# **Awel y Môr Offshore Wind Farm Examination Review of SLVIA Documents**

**Final report**  
Prepared by LUC  
October 2022

### Awel y Môr Offshore Wind Farm Examination Review of SLVIA Documents

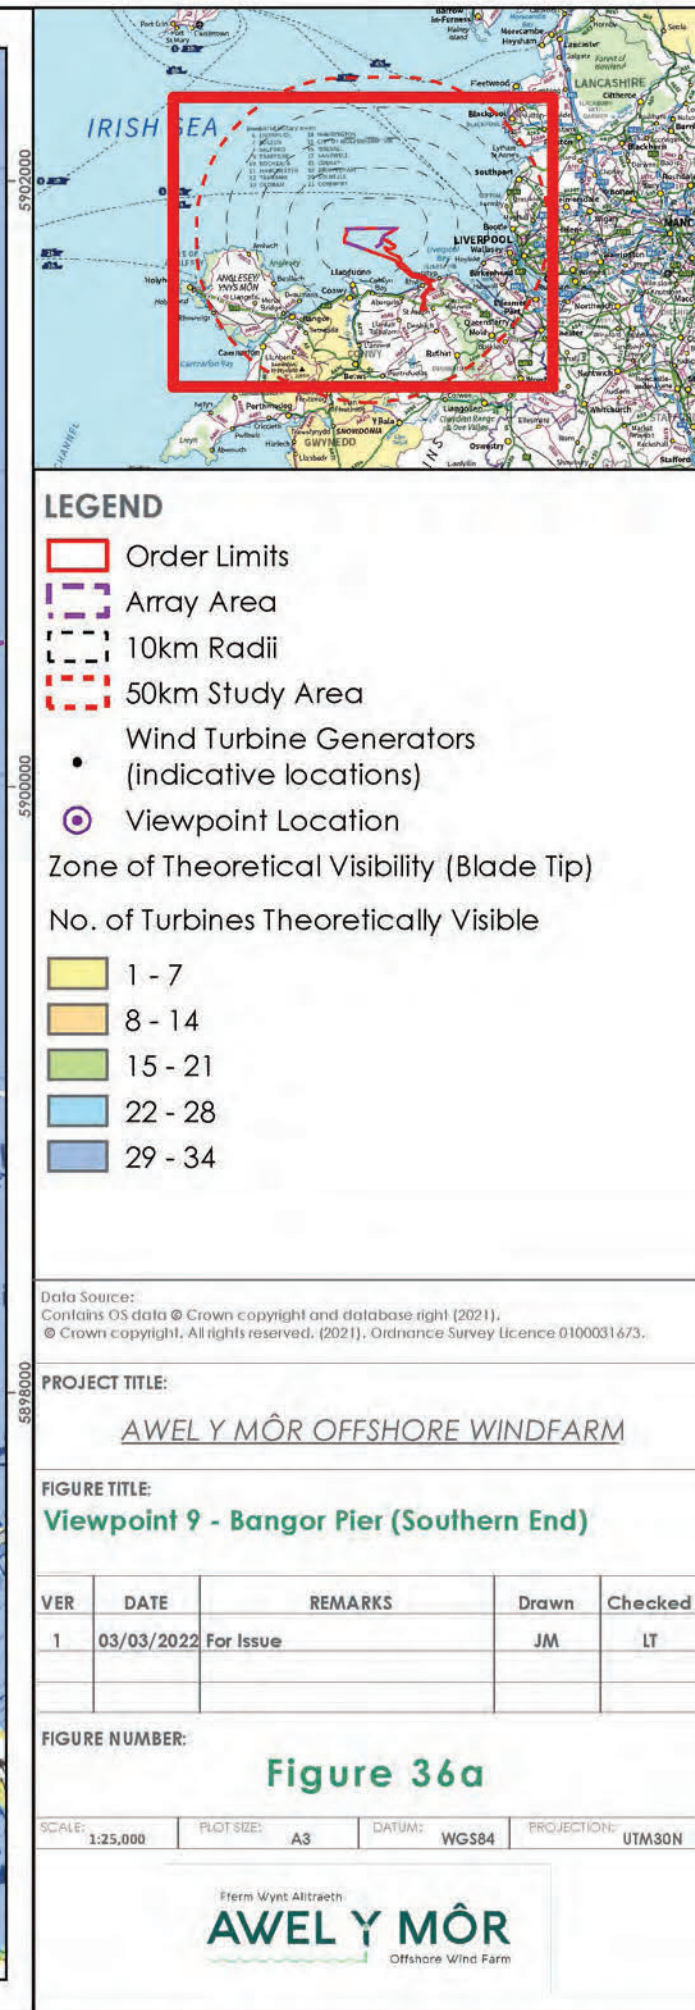
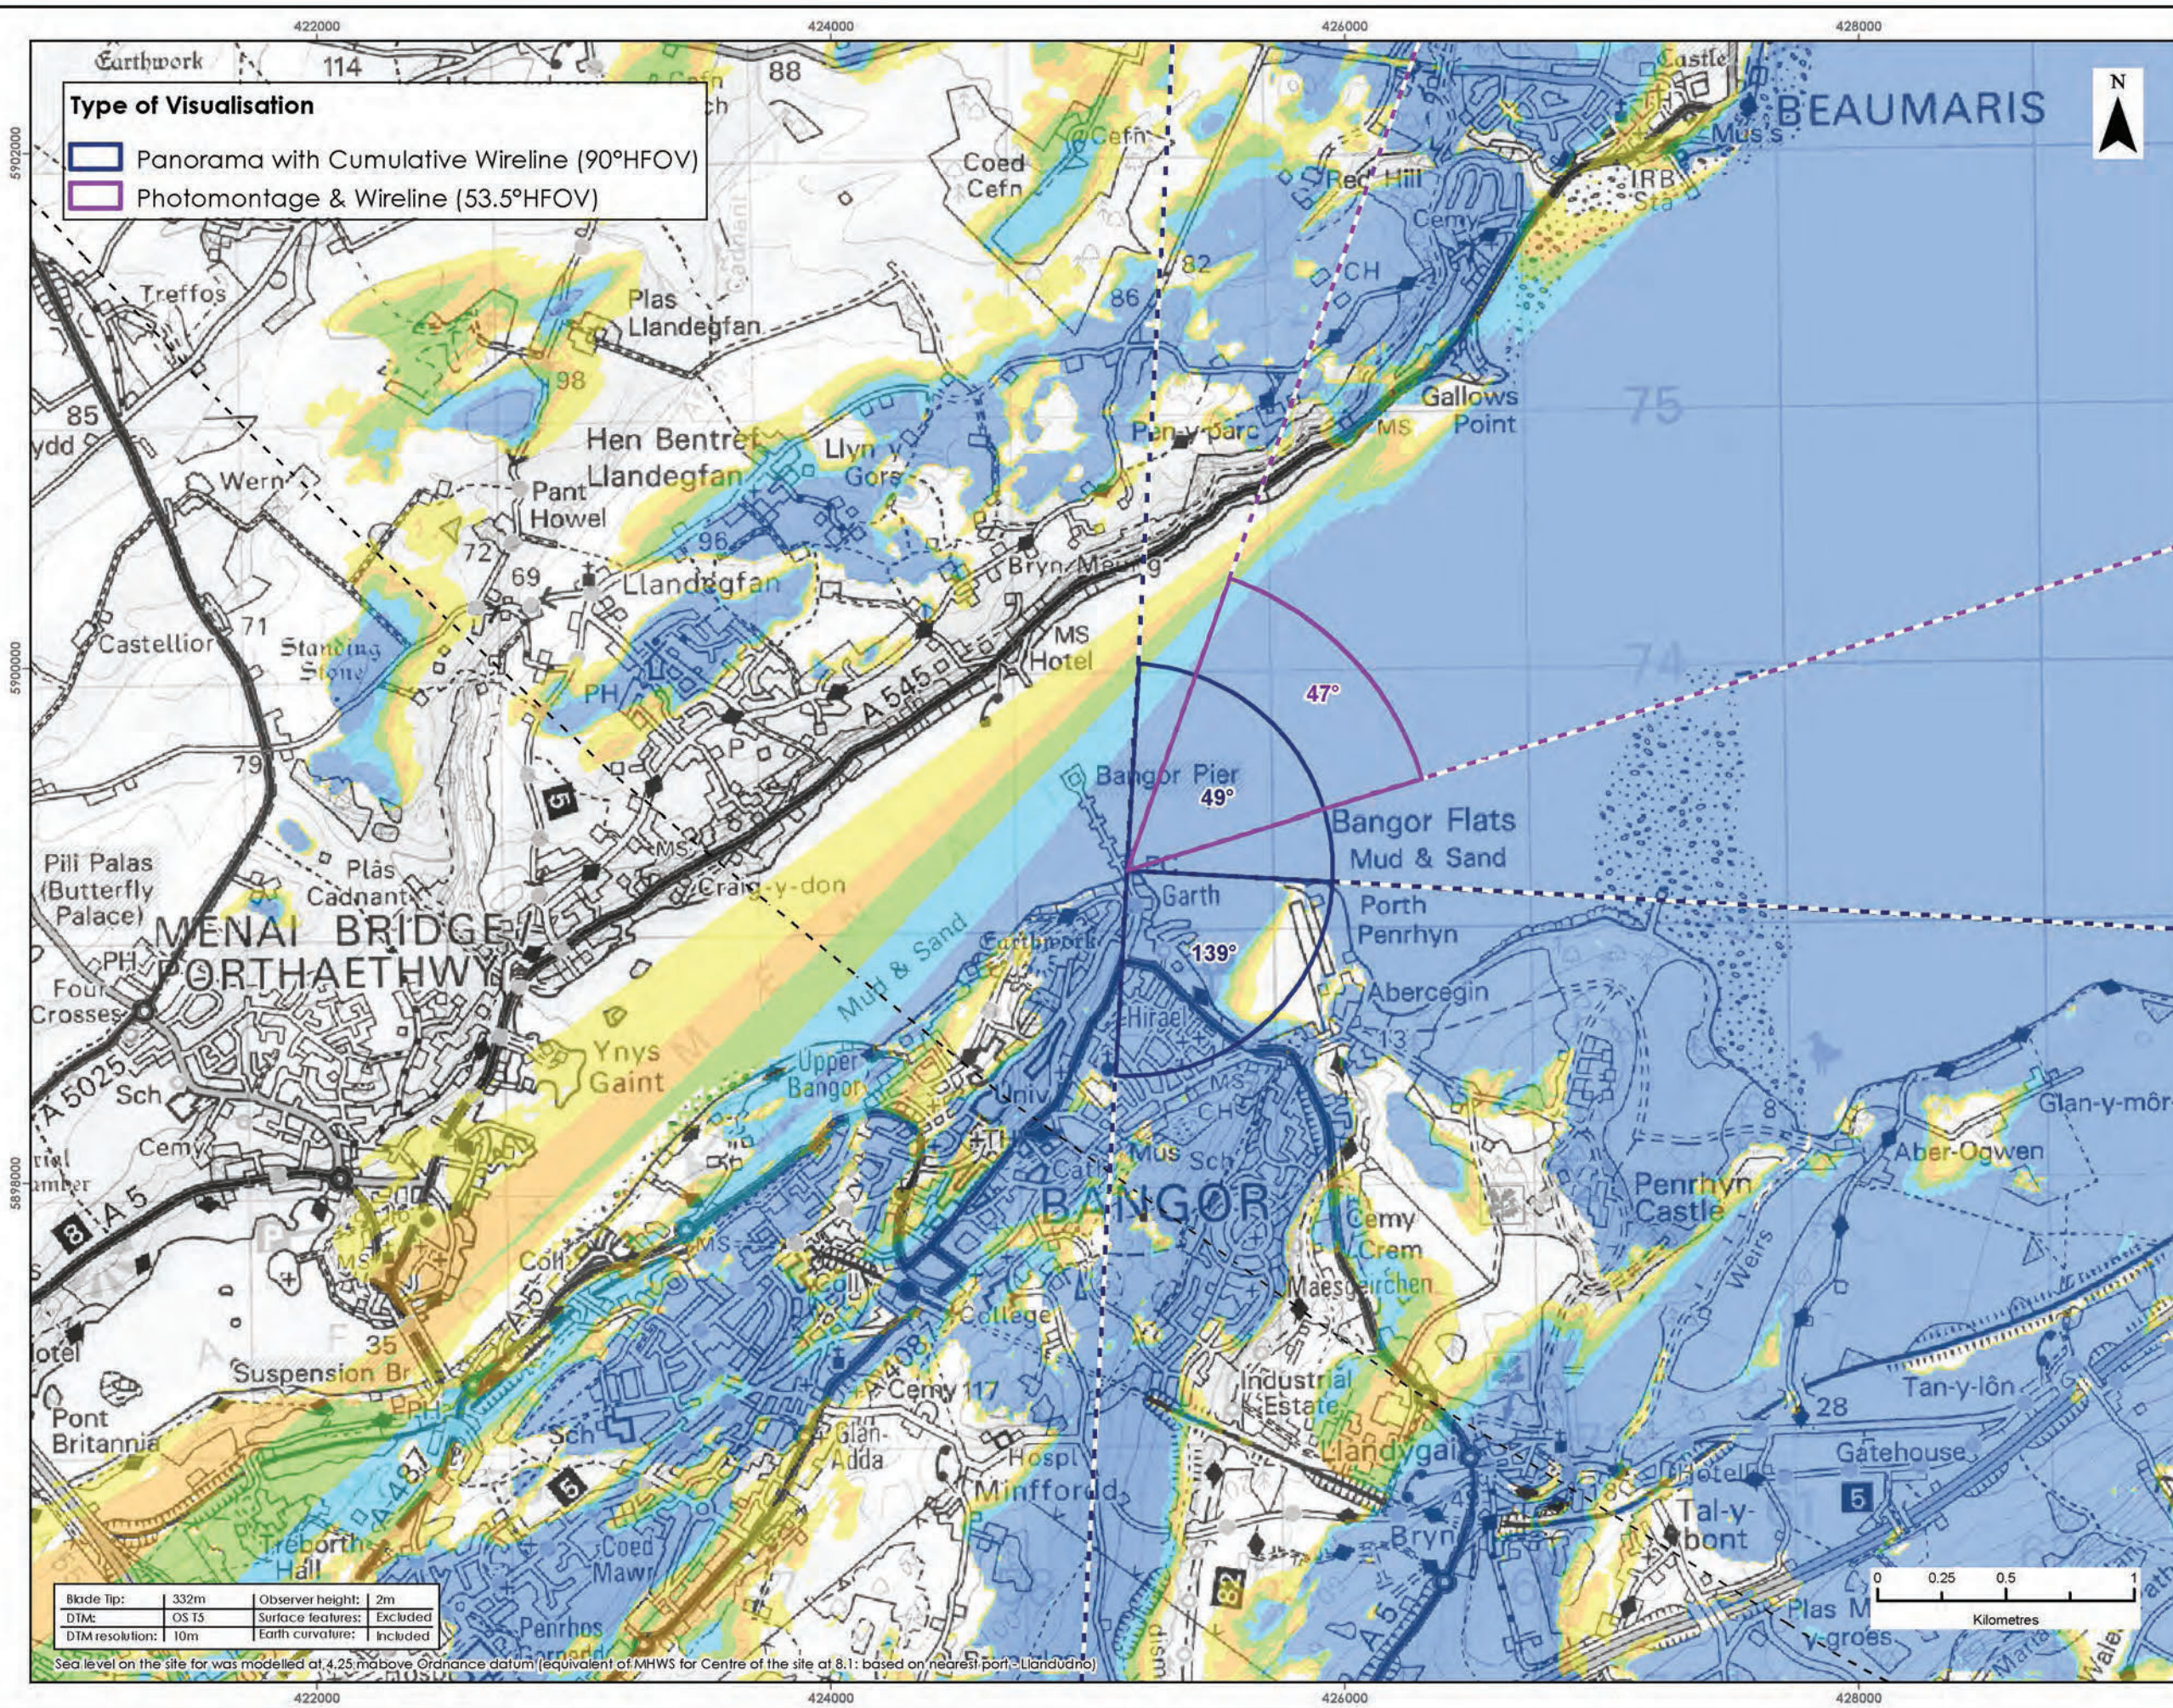
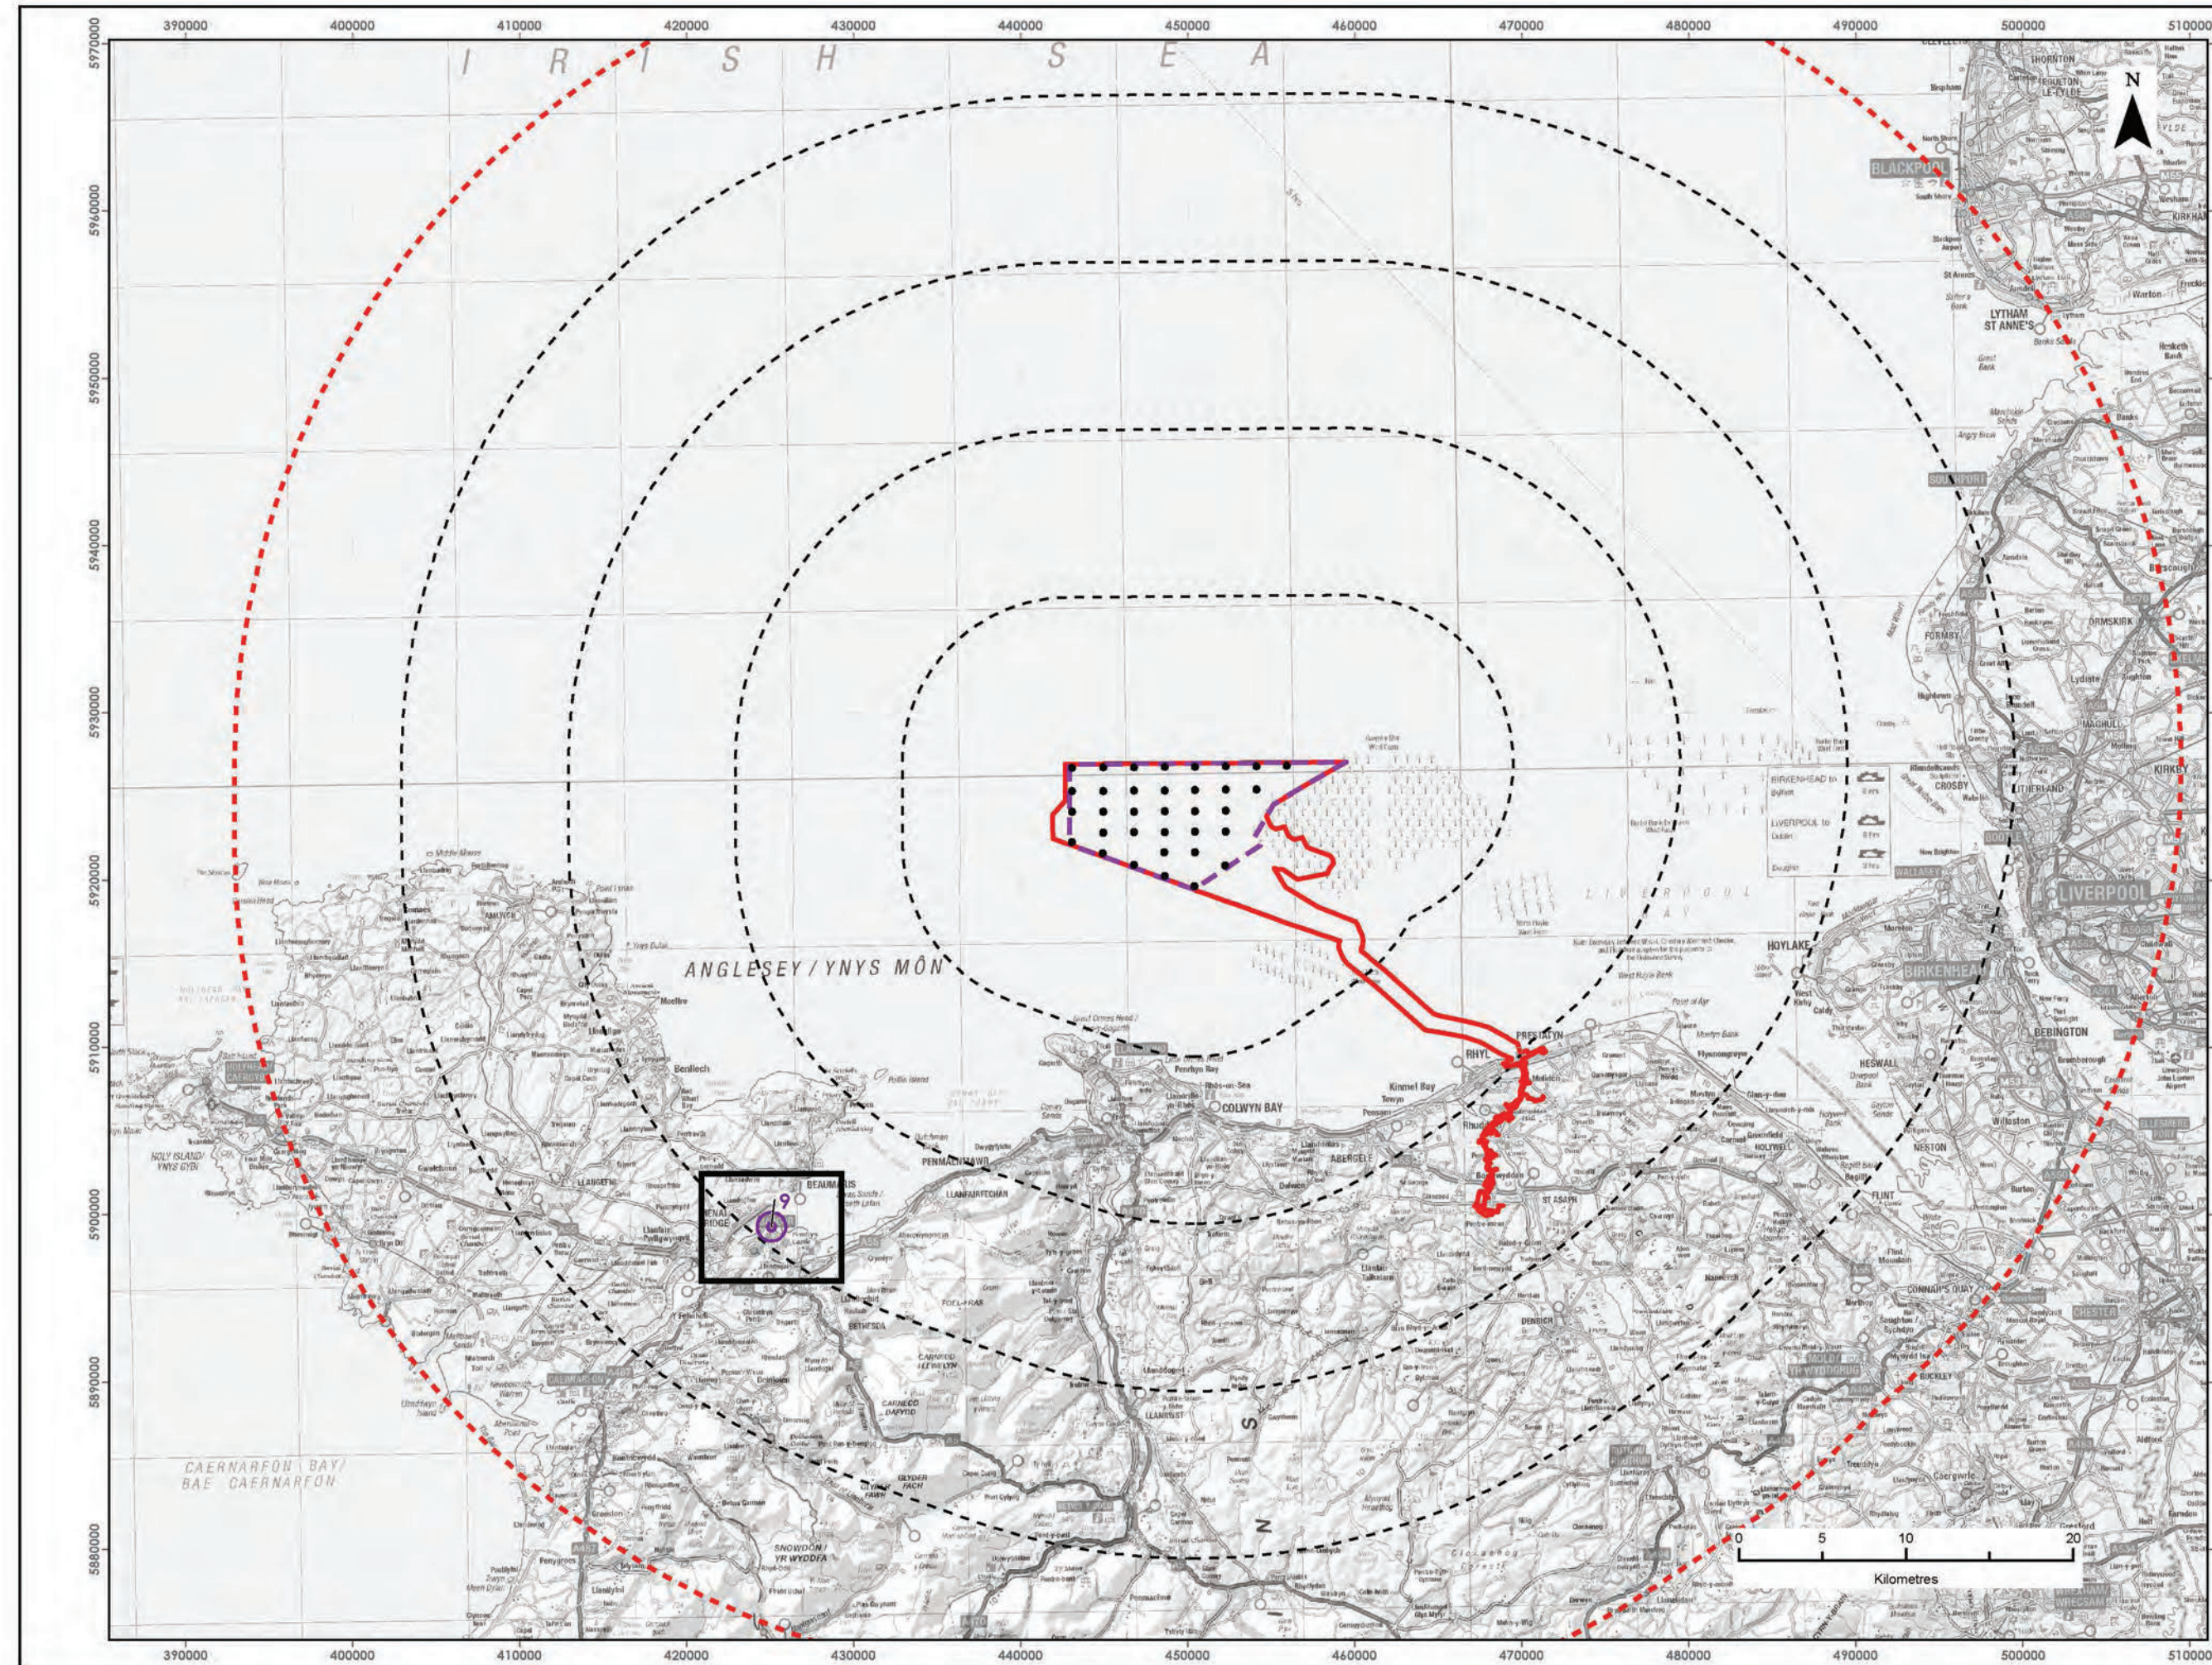
**3.18** We queried the finding of non-significant effects at VP17 Penrhyn Castle Terrace. The SLVIA authors have revisited this in light of stakeholder comments, and a moderate (significant) effect is now recorded. Moderate (significant) effects are also confirmed for VP9 Bangor Pier.
